## **Lead Local Flood Authority (Flood Management & Drainage) – Statutory Consultation**

**Consultation on Application Number: 2018/90735**

**Address: Marsden Fire Station, Manchester Road, Marsden, Huddersfield, HD7  
6HA**

**Proposal: Demolition of former fire station and erection of 24no. two bedroom  
flats, 2no. single bedroom flats and 1no. dwelling, associated parking, new  
vehicular access and landscaping (within a Conservation Area)**

### PLANNING LAYOUT

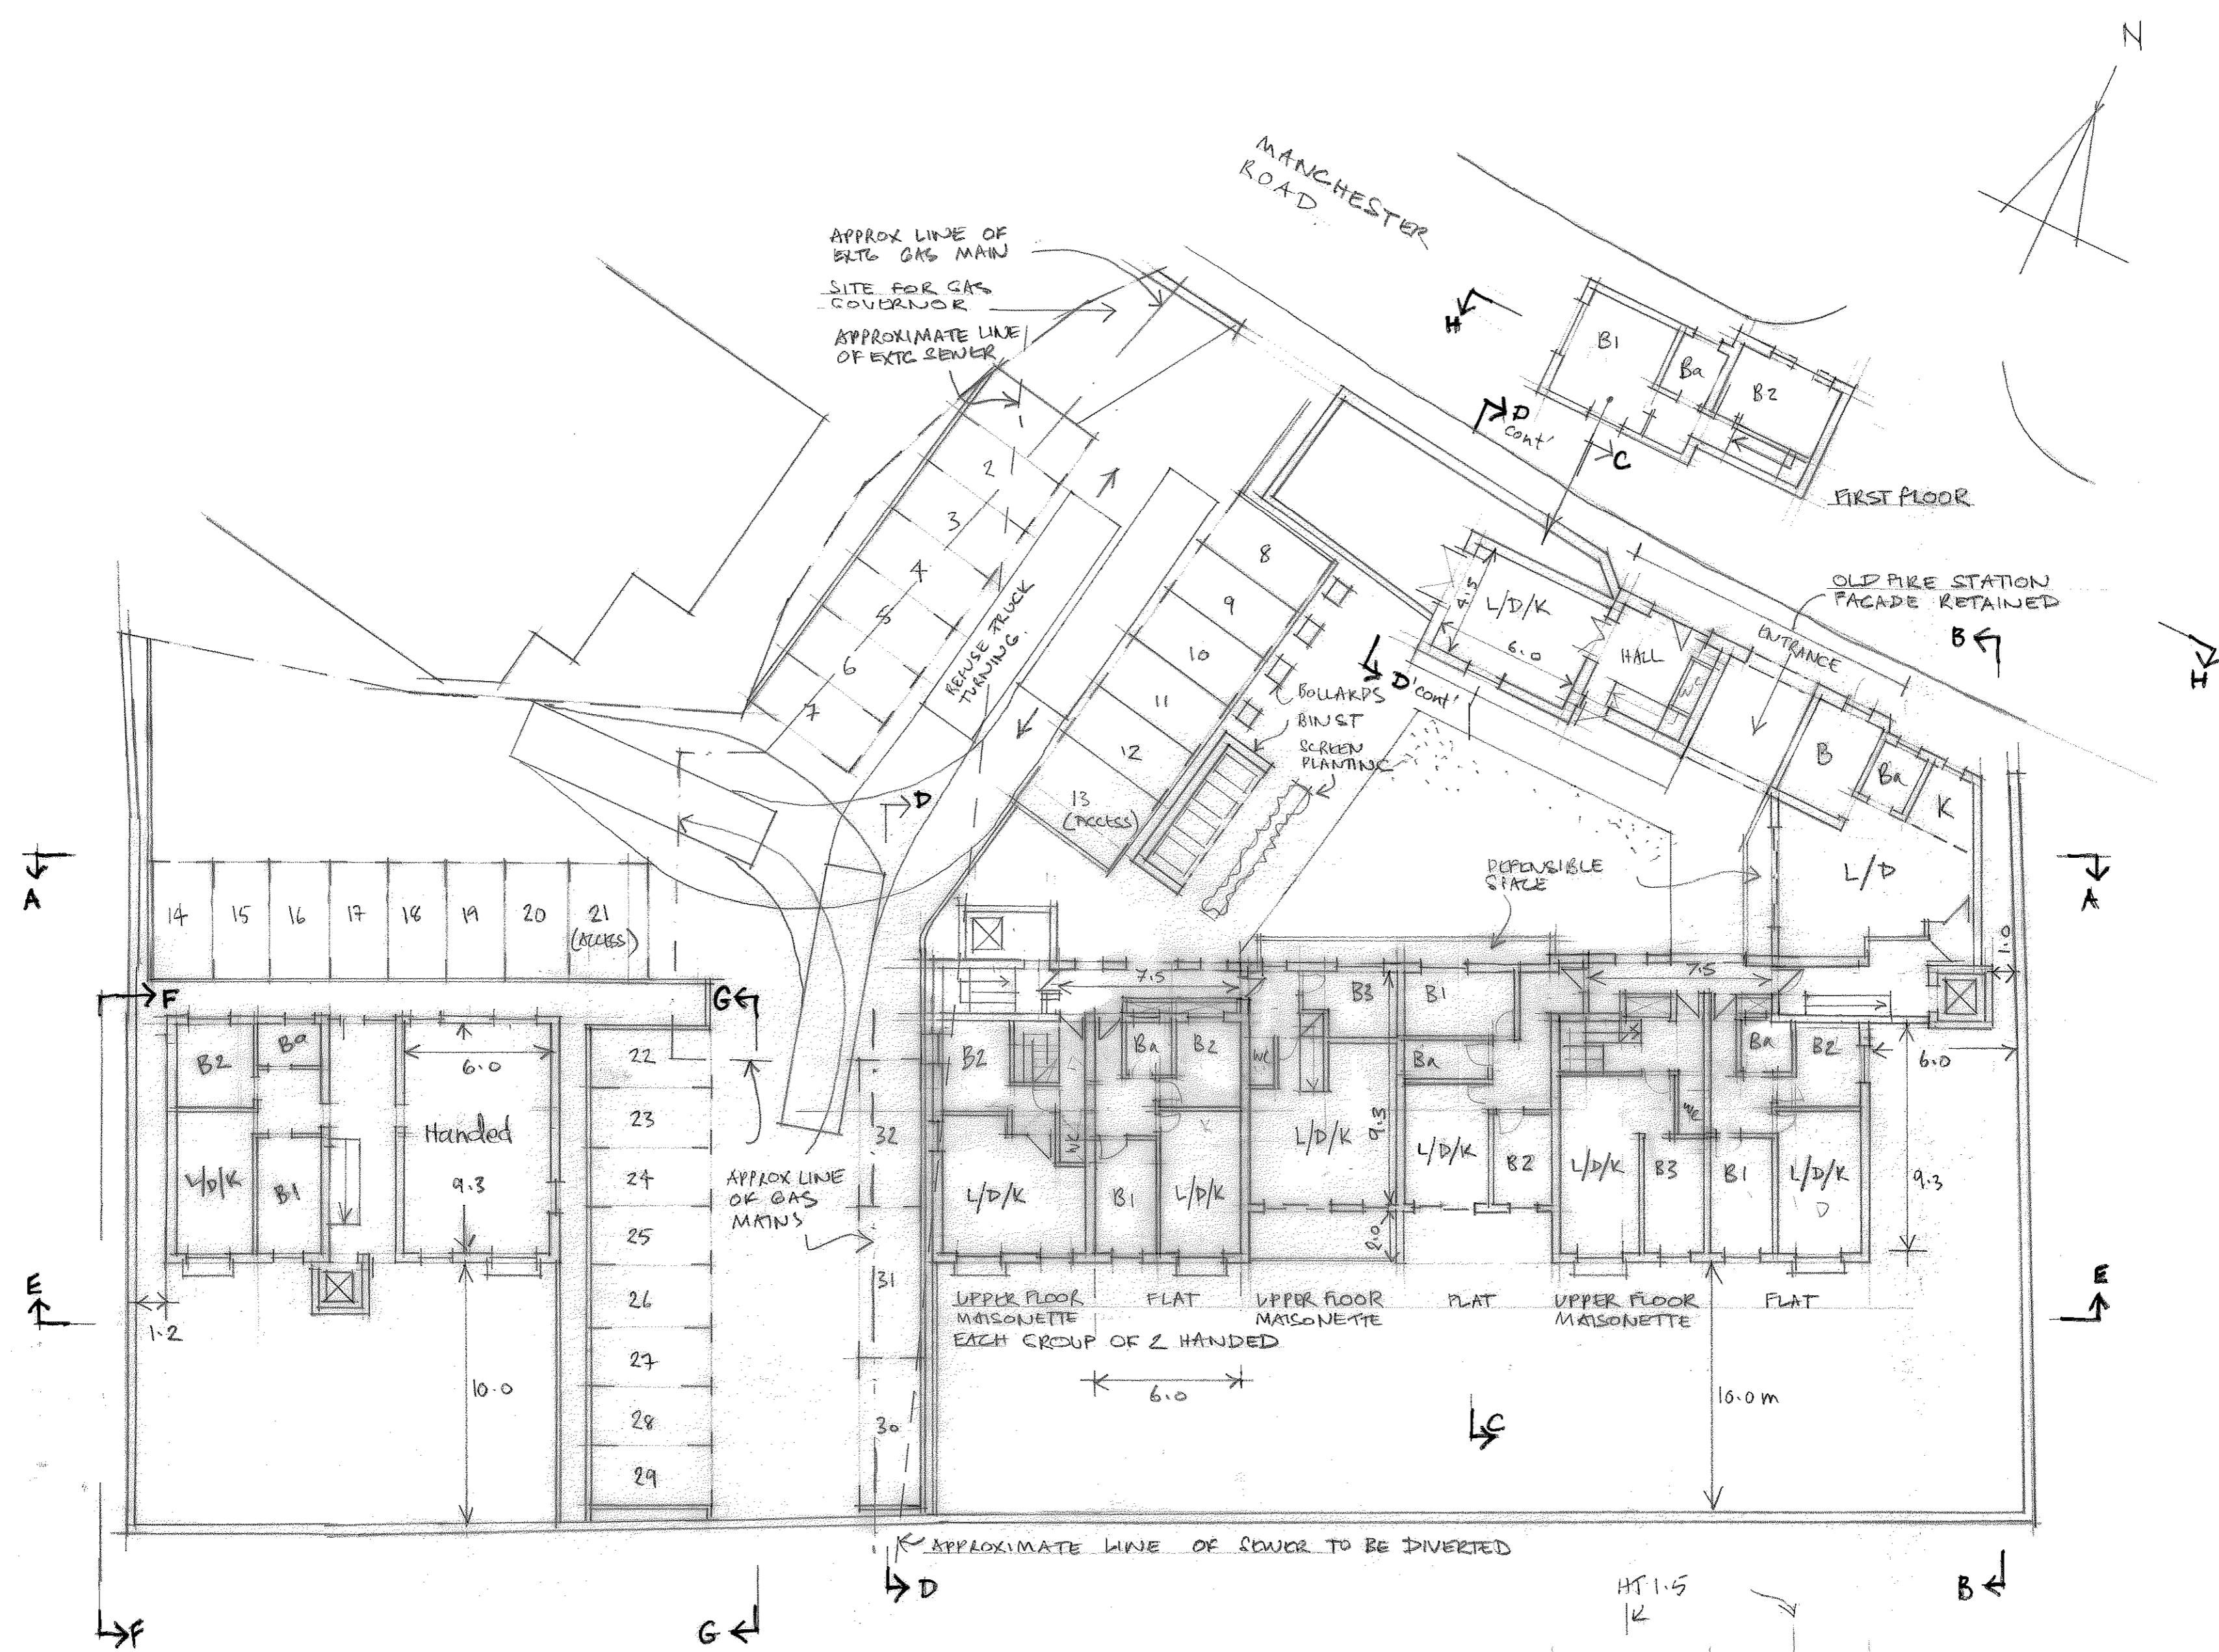
A connection to public sewer is possible. Yorkshire Water must be consulted over appropriate stand-off distances to the public combined sewer that crosses site. It would appear that although there is hardstanding areas, no evidence has been

produced that it is positively drained. Rainwater pipes exist on the fire station building and a survey will be required to reveal existing drainage connection points to a given system. It is likely that a minimal discharge rate, lower than that indicated in the submitted flood risk assessment will be granted. Space for attenuation is however available on site and therefore drainage can be conditioned.
